**WEST SUSSEX COUNTY COUNCIL
STRATEGIC PLANNING CONSULTATION**

SUBJECT: BR/80/17/PL - 1No. detached two bed bungalow. Resubmission of BR/163/16/PL.

Land East of Pumping Station, Highcroft Close, Bognor Regis, PO22 8DS

PROPOSED GROUND FLOOR PLAN
& SITE BLOCK PLAN.

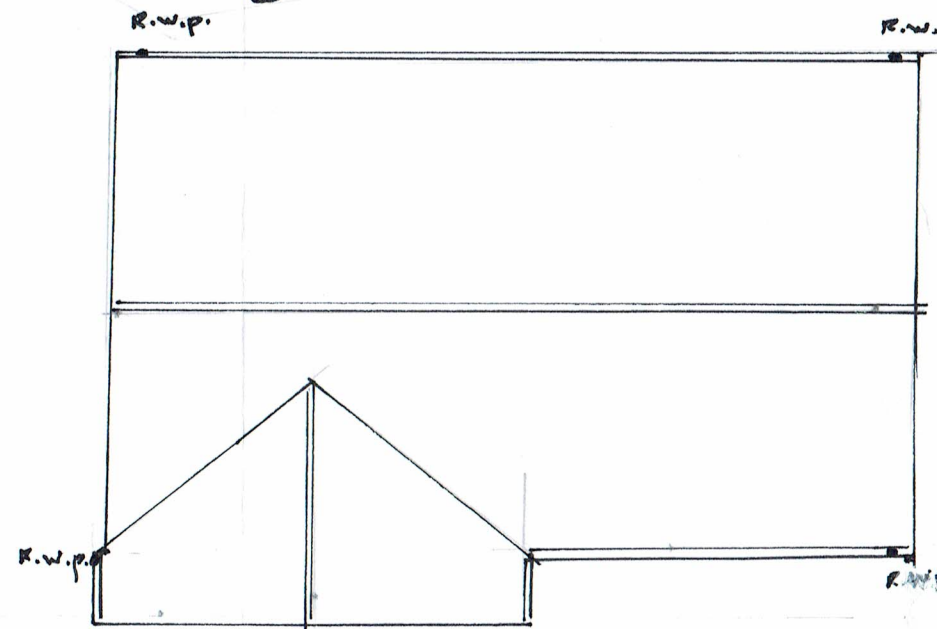
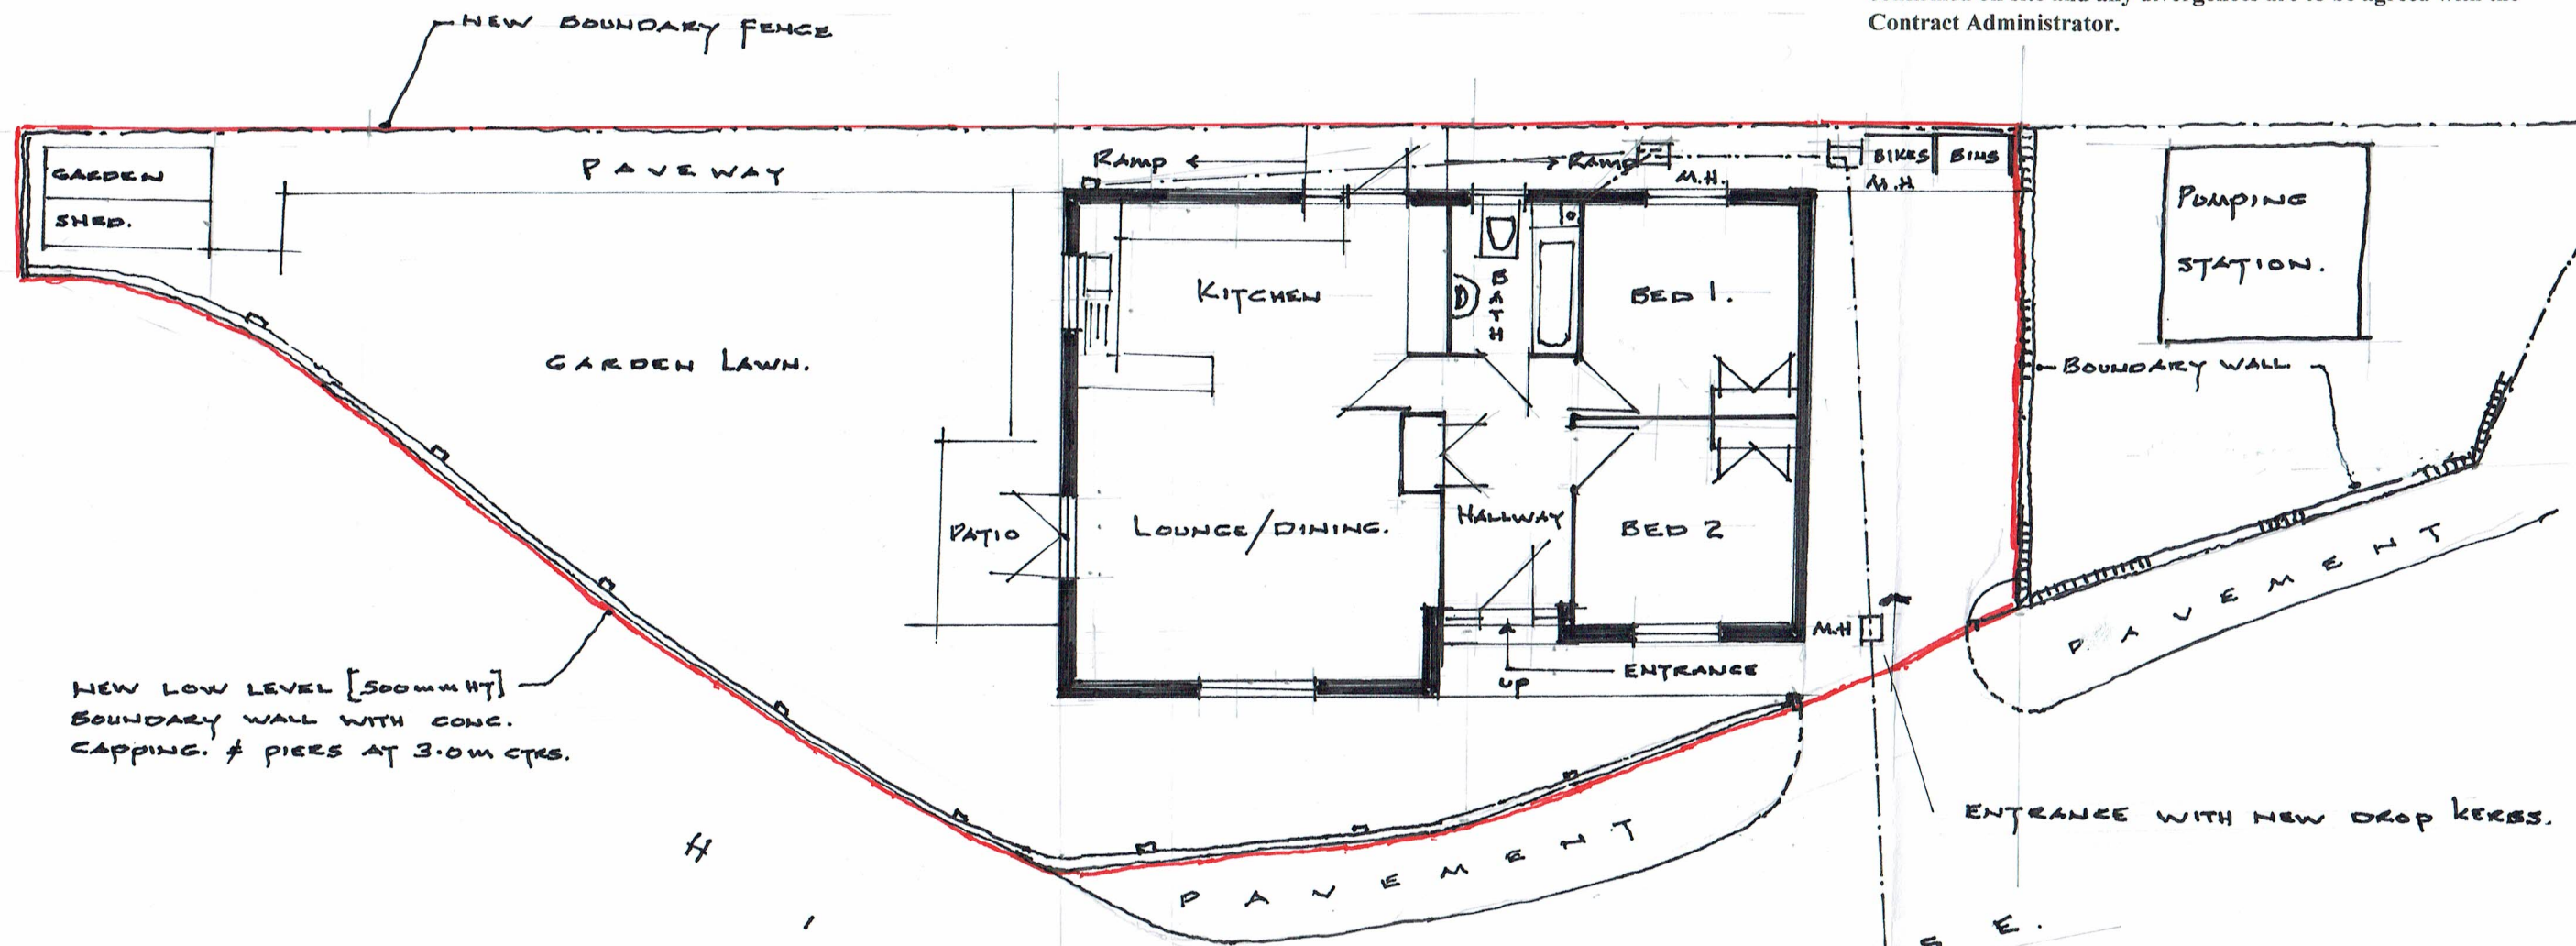
The application form states that off-street parking for up to 2 vehicles will be provided. A study of the block plan demonstrates that there appears to be insufficient space on-site for two vehicles to park. Whilst this does not necessarily pose a highway safety concern, there could be an amenity issue that the LPA may wish to consider.

The access is located adjacent to the pumping station boundary wall resulting in limited pedestrian visibility for a car exiting the back edge of the footway. However, Manual for Streets 2 (MfS2) para 10.6.1 states that "*vehicle exits at the back edge of the footway mean that emerging drivers will have to take account of people on the footway. The absence of wide visibility splays at minor accesses will encourage drivers to emerge more cautiously - similarly to how vehicles pull out when visibility along the carriageway is restricted*".
